WOODLAND CONSULTANCY LIMITED

**Report on Ecological Appraisals Presented in Support
of Applications For Housing Development at
Pagham, West Sussex**

March 2017

Figure 5 6932-E-05

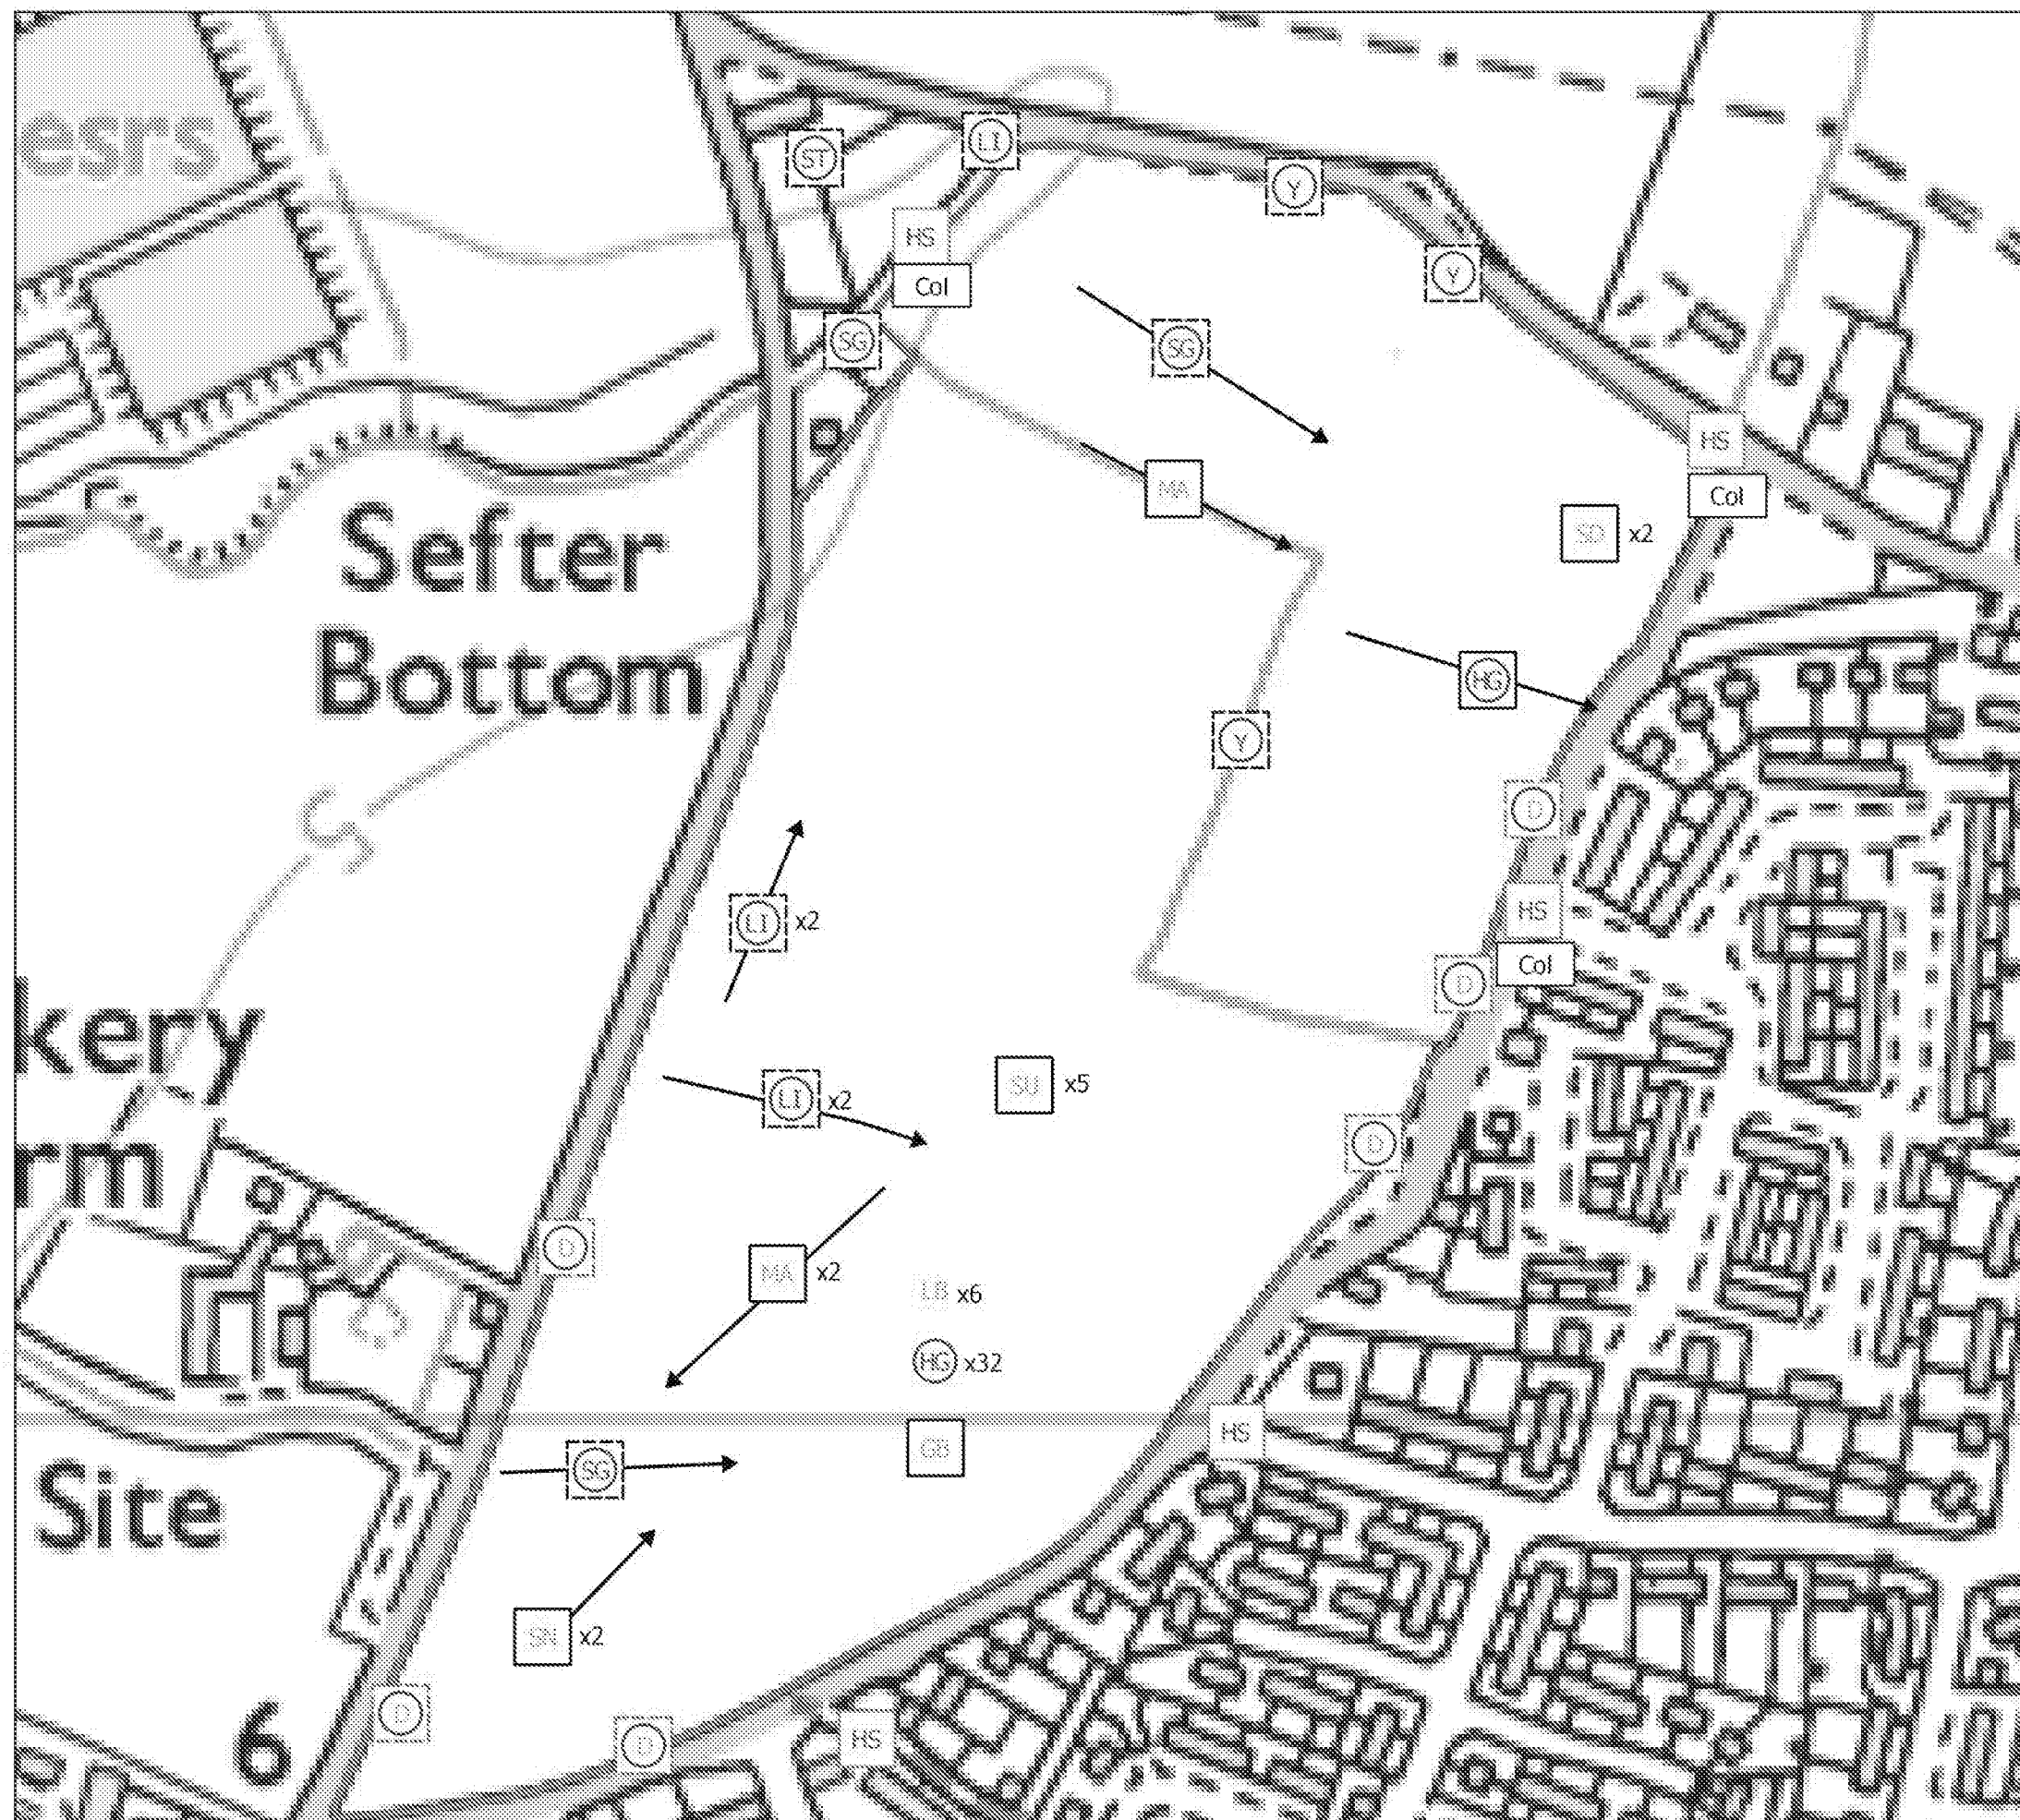
5.2.3 Natural England advised in October 2015 that *'Arable land used by Brent geese in the vicinity of Pagham Harbour can be important supporting habitat which may have a functional link with the ecological integrity of the SPA. We advise that bird surveys should be carried out throughout the winter to establish whether Brent Geese are using the application site'*. The Winter Bird Surveys documented in the Ecological Appraisal recorded no Brent geese and it was concluded that the development would have no significant effect on the Pagham Harbour SPA alone or in combination. However photographic evidence has been provided by local residents of a large flock of Dark-bellied Brent geese on the application site on 10th February 2017, see figure 5 below, therefore this conclusion is unsafe.
